PLAN REVIEW SHEET

Petition #: RZP 2022-190

Address: 520 Providence Rd.

Request: UR-C (CD) SPA

**RZ-1.0**

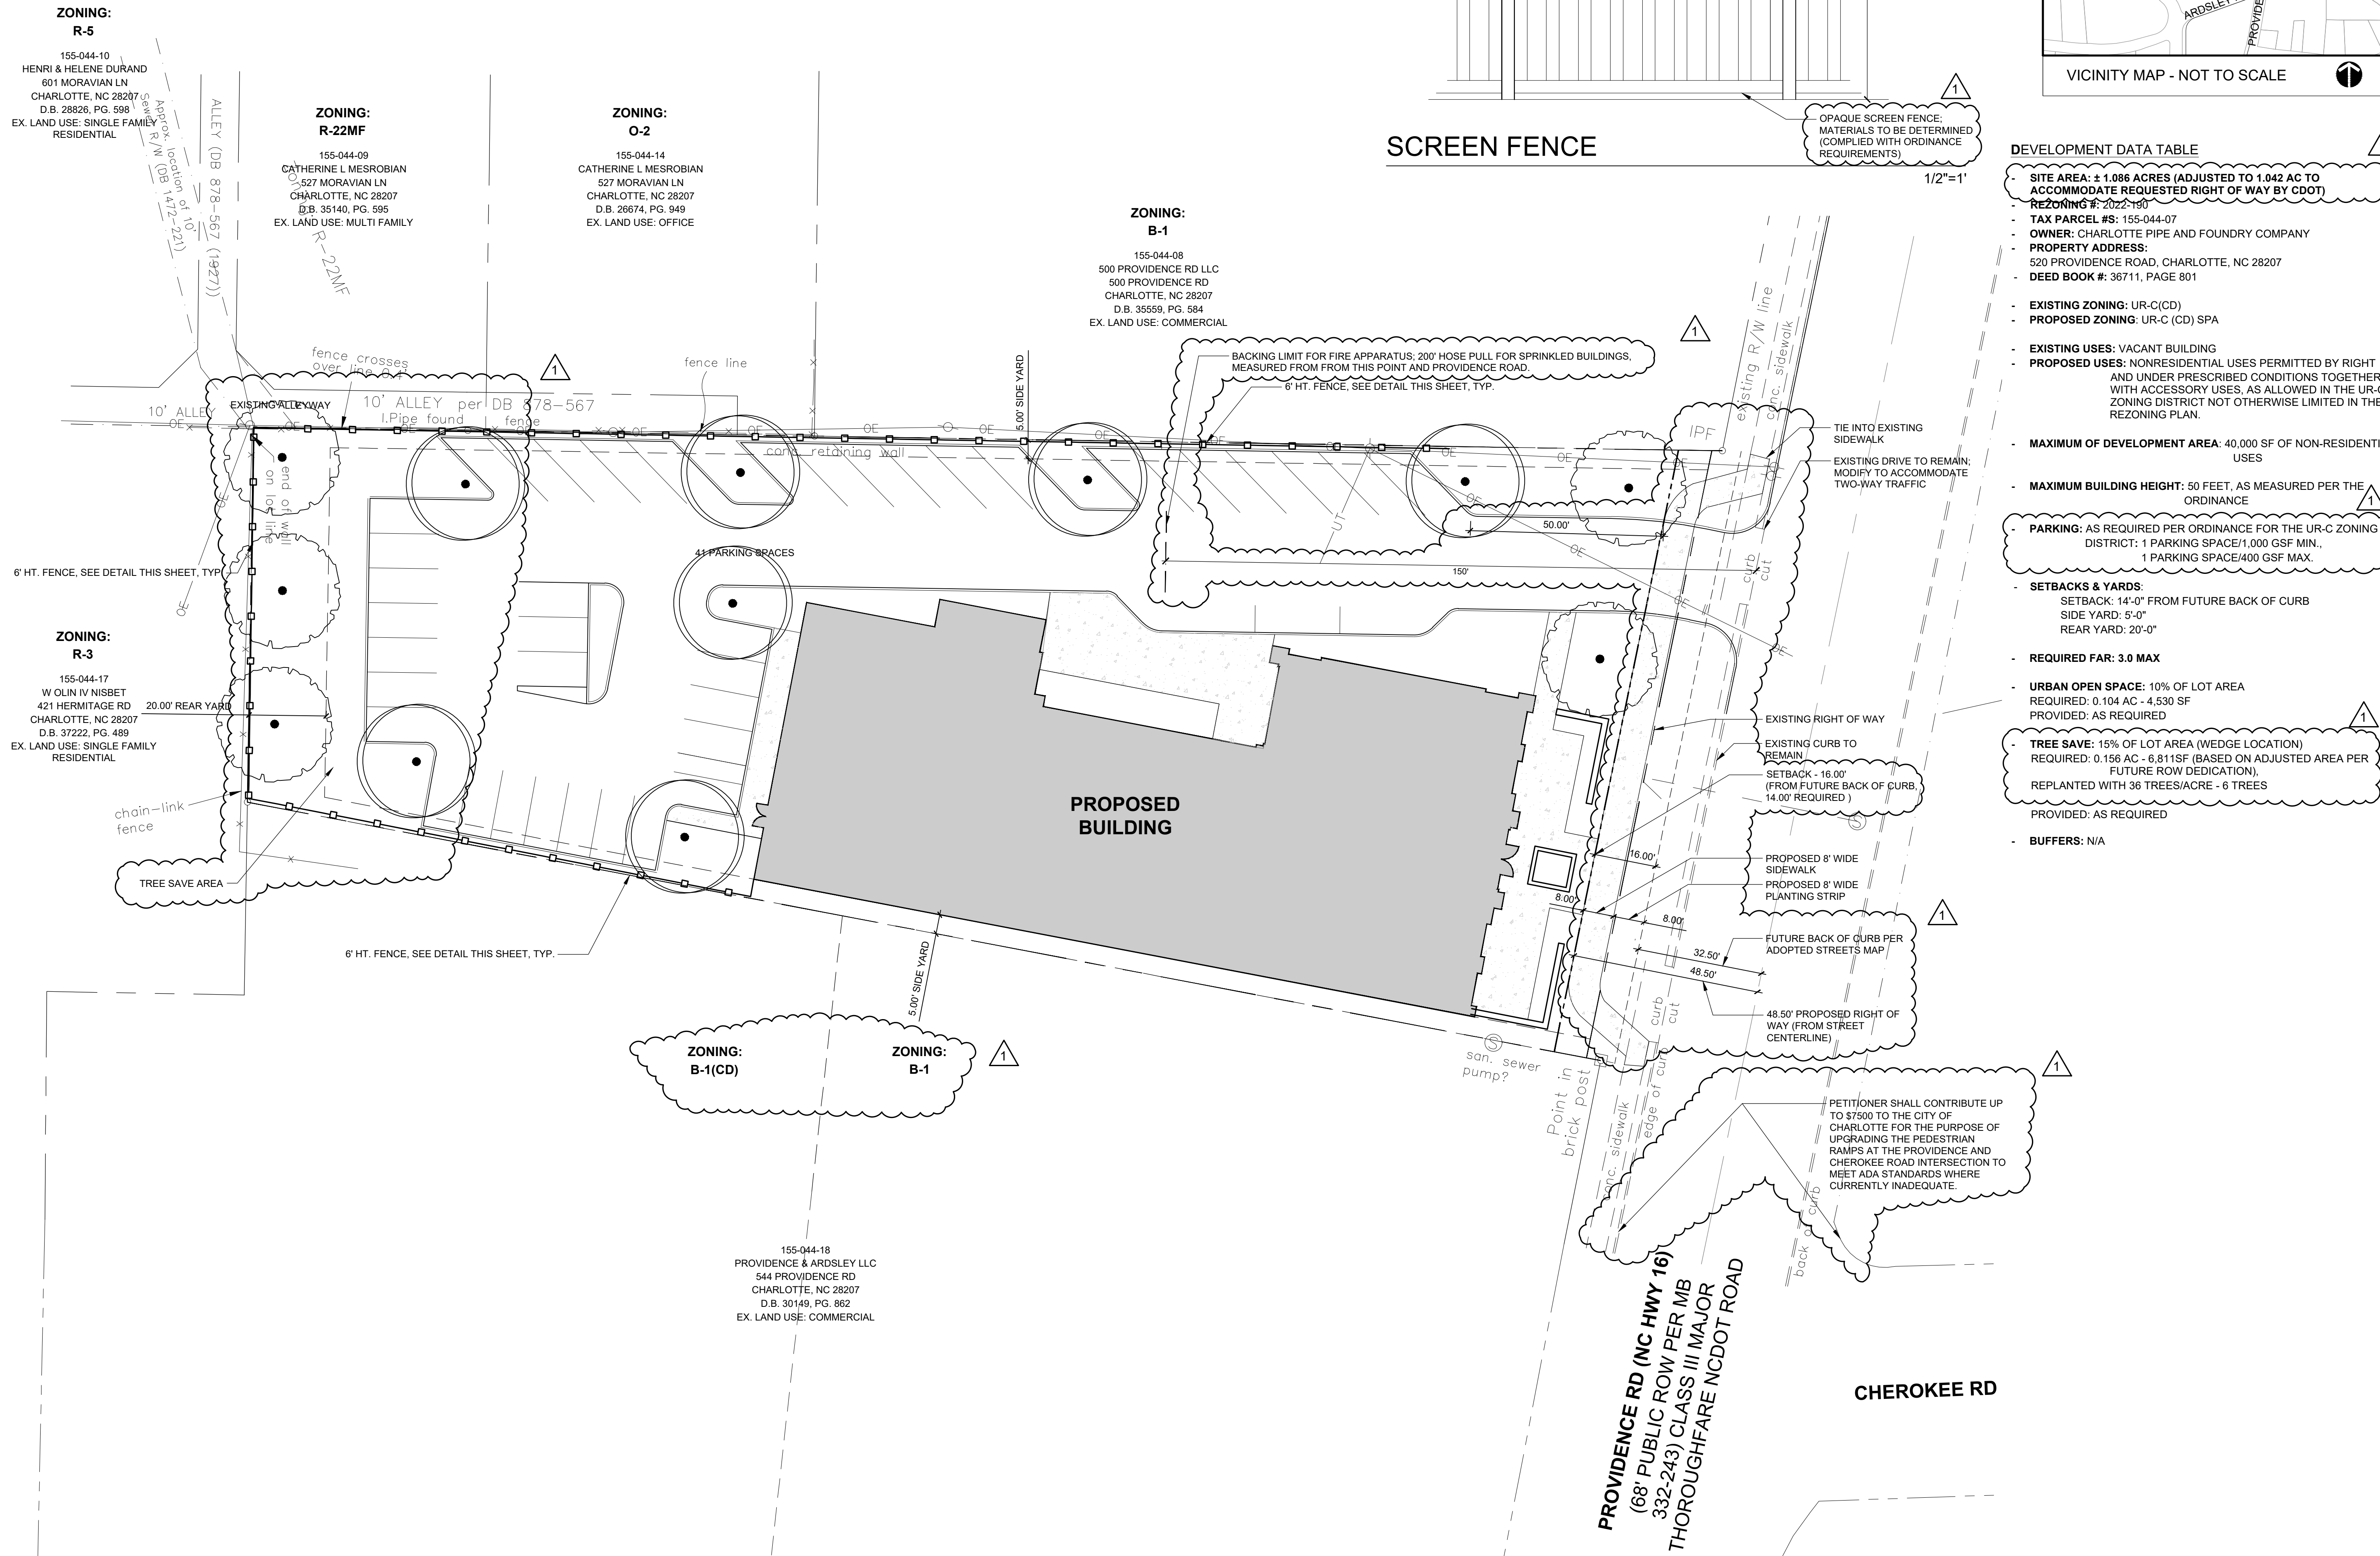
The site is located along CATS local bus route #14 on Providence Road. CATS requests the construction of ADA compliant bus standard detail 60.02A on Providence Road at the southern corner of the property frontage closest to Cherokee Road. The final location will be coordinated with the developer during the Land Development plan review process.
